CITY OF ALBUQUERQUE

June 28, 2016

Re: APS La Cueva ISP & Weight Room Renovation & Addition
7801 Wilshire Ave., NE
Traffic Circulation Layout
Engineer's/Architect's Stamp dated 5-23-16 (C19-D004)

SHEET TITLE
CIVIL SITE PLAN

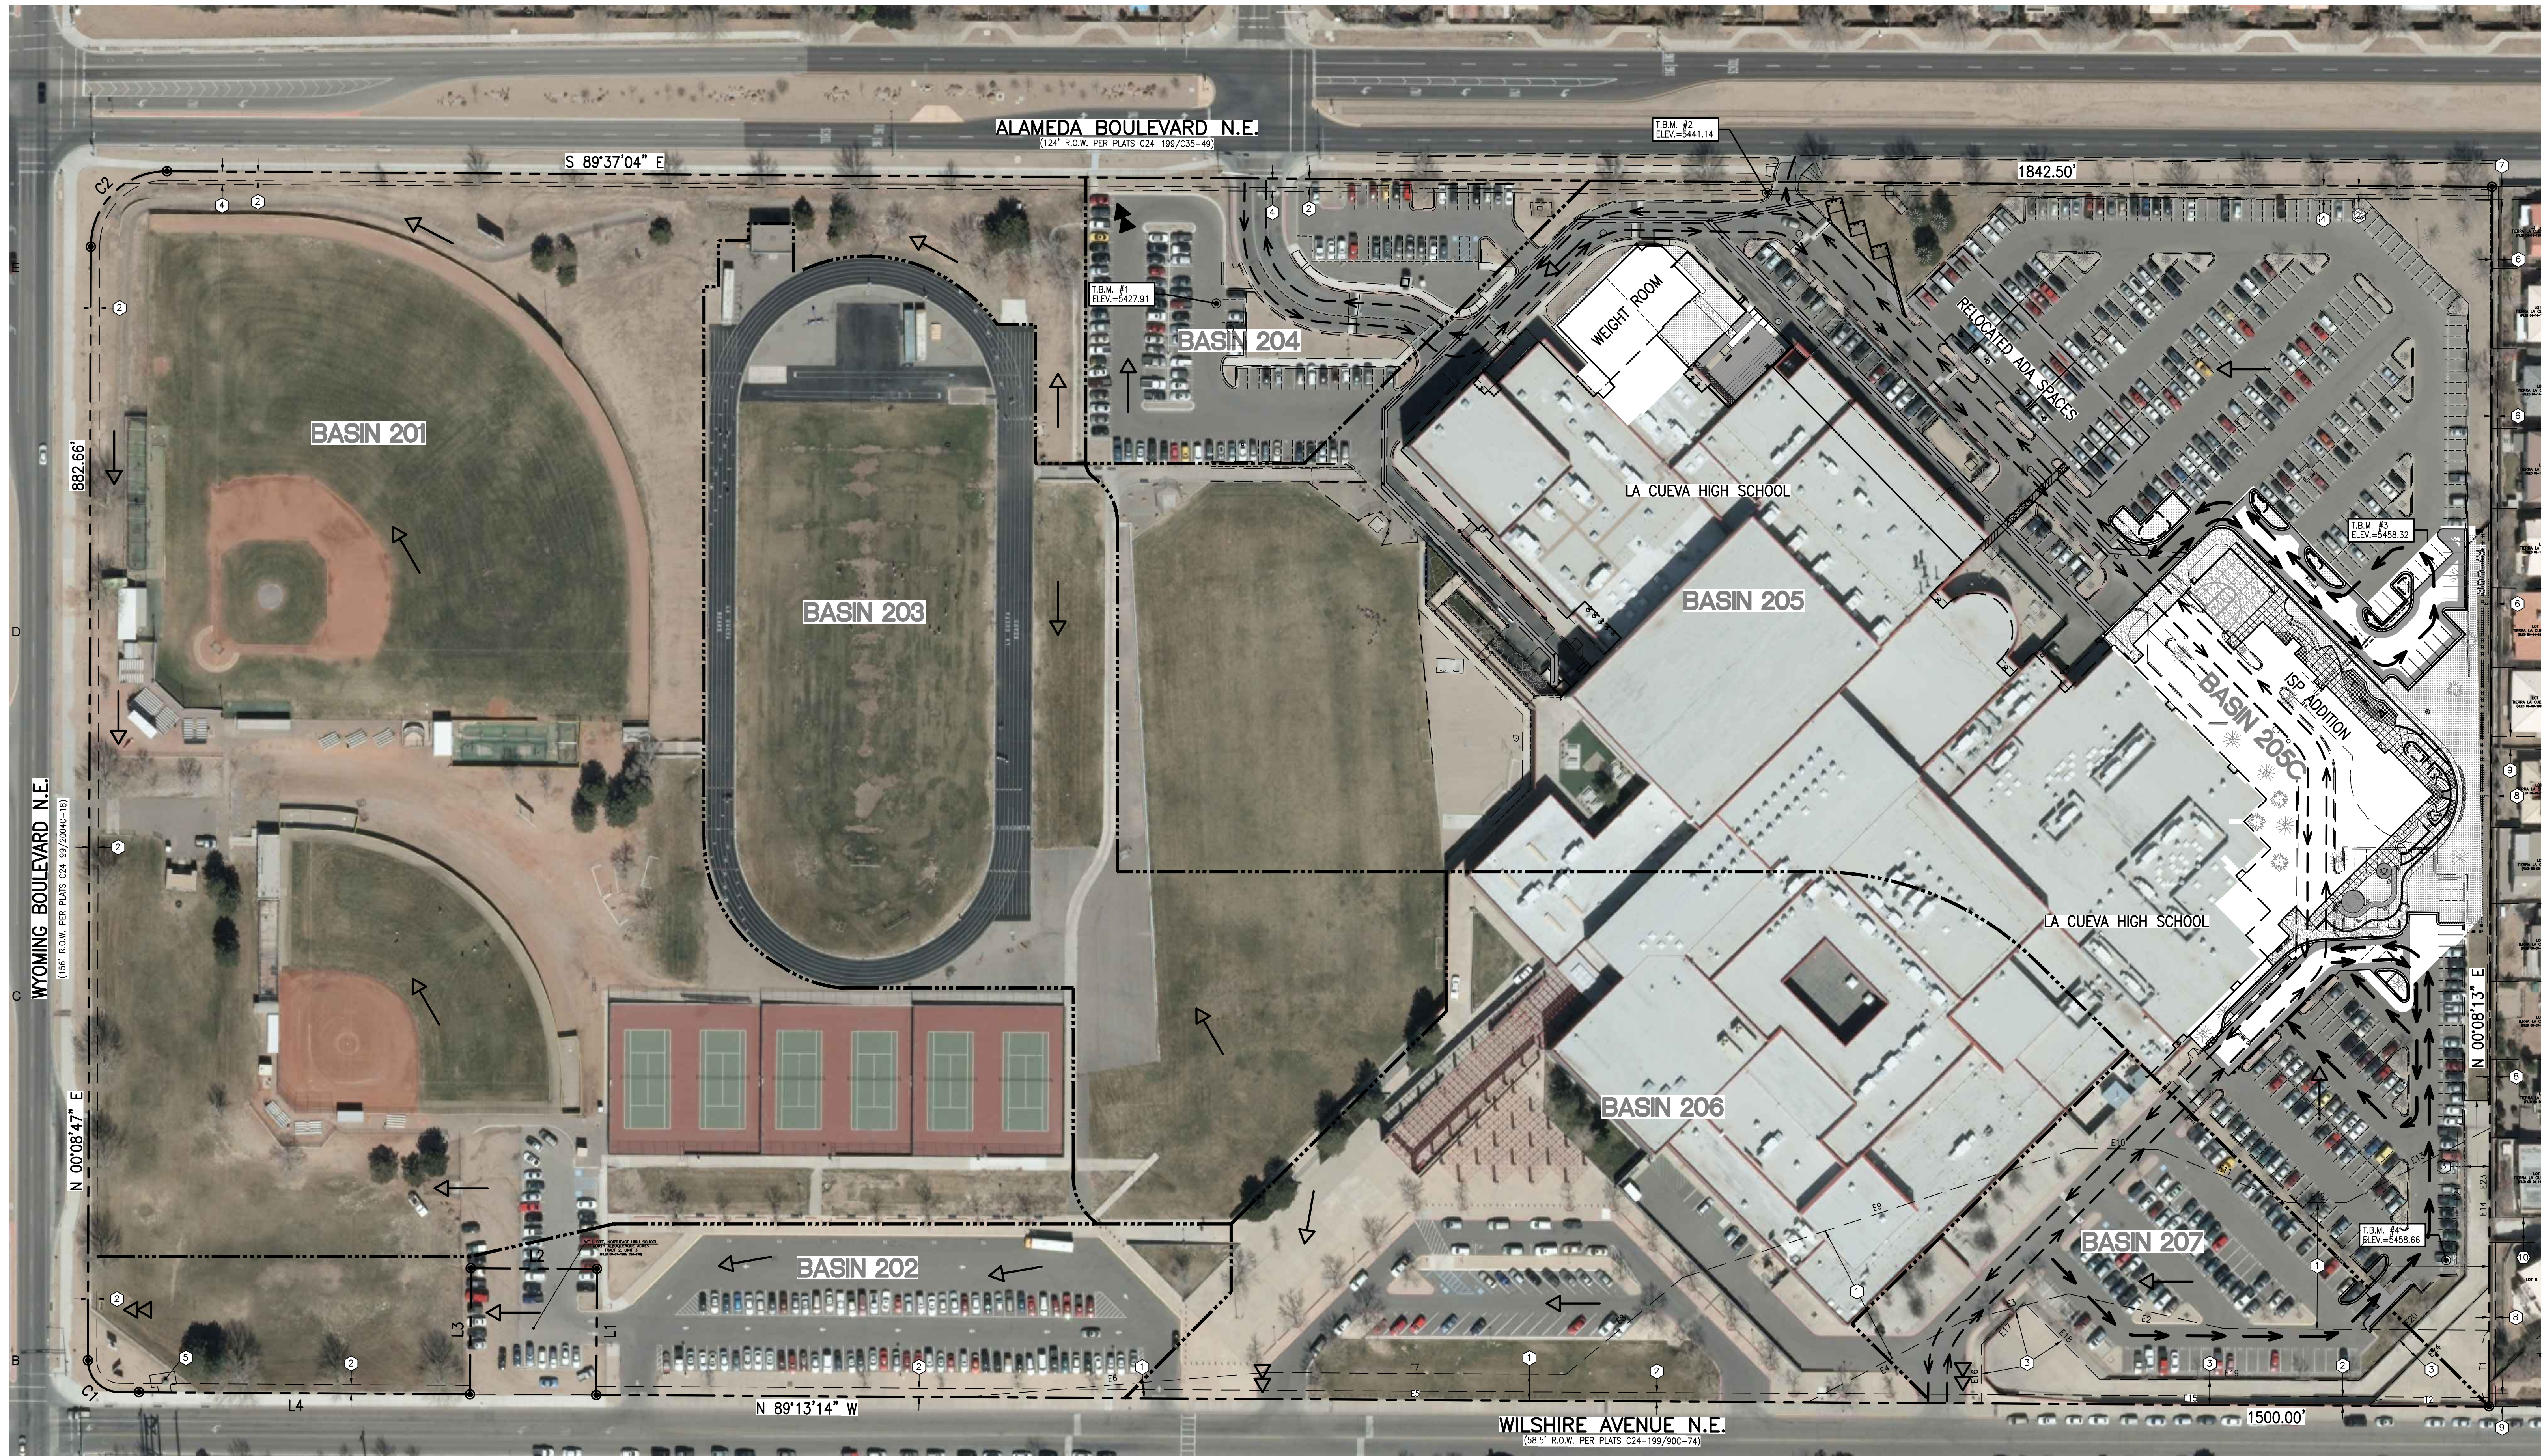
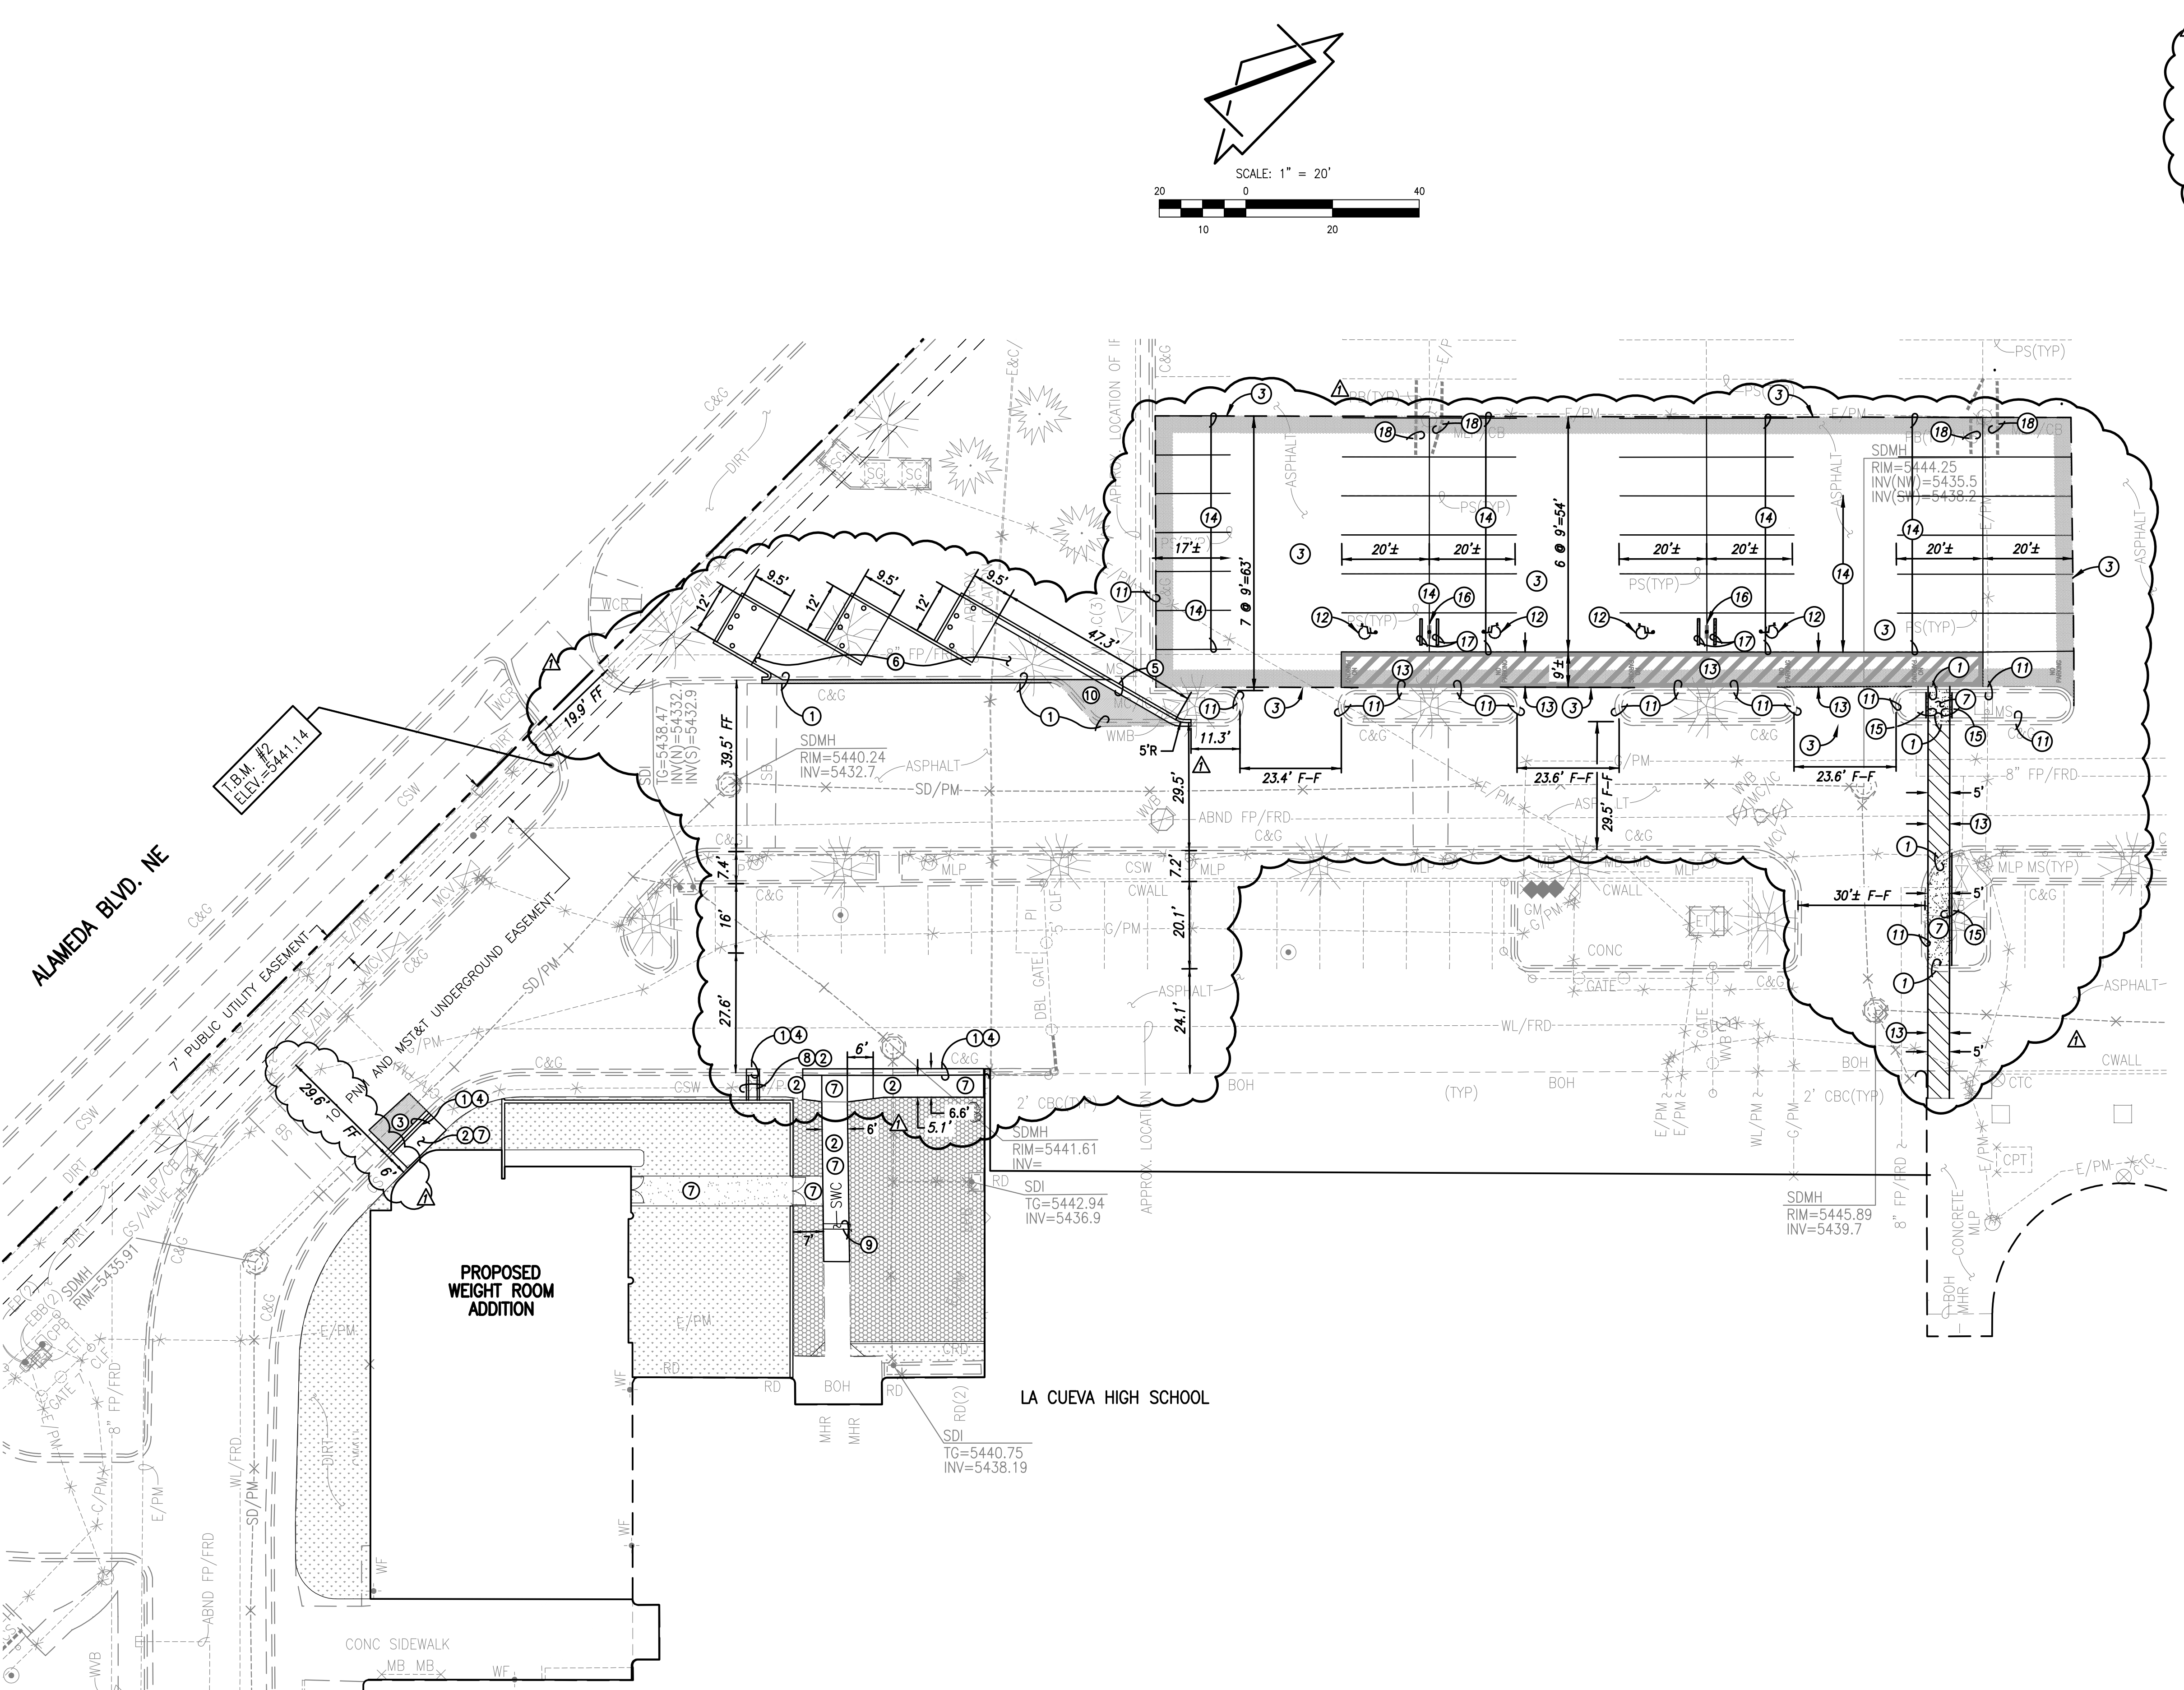
We have received the TCL submittal for BP for the La Cueva HS renovations. Please send us some further information regarding the changes to the entire site. Mrs. Crystal Metro is no longer with COA, so we are not familiar with the project. We will also need usual details and dimensions, such as parking space dimensions, drive pad entrance widths, sidewalk width, etc.

*Met 5/31/16
to resubmit
w/ ADA parking specs
w/ dimensions*

The TCL submittal received 6-27-16 is approved for Building Permit. A copy of the stamped and signed plan will be needed for each of the building permit plans. Please keep the original to be used for certification of the site for final C.O. for Transportation.
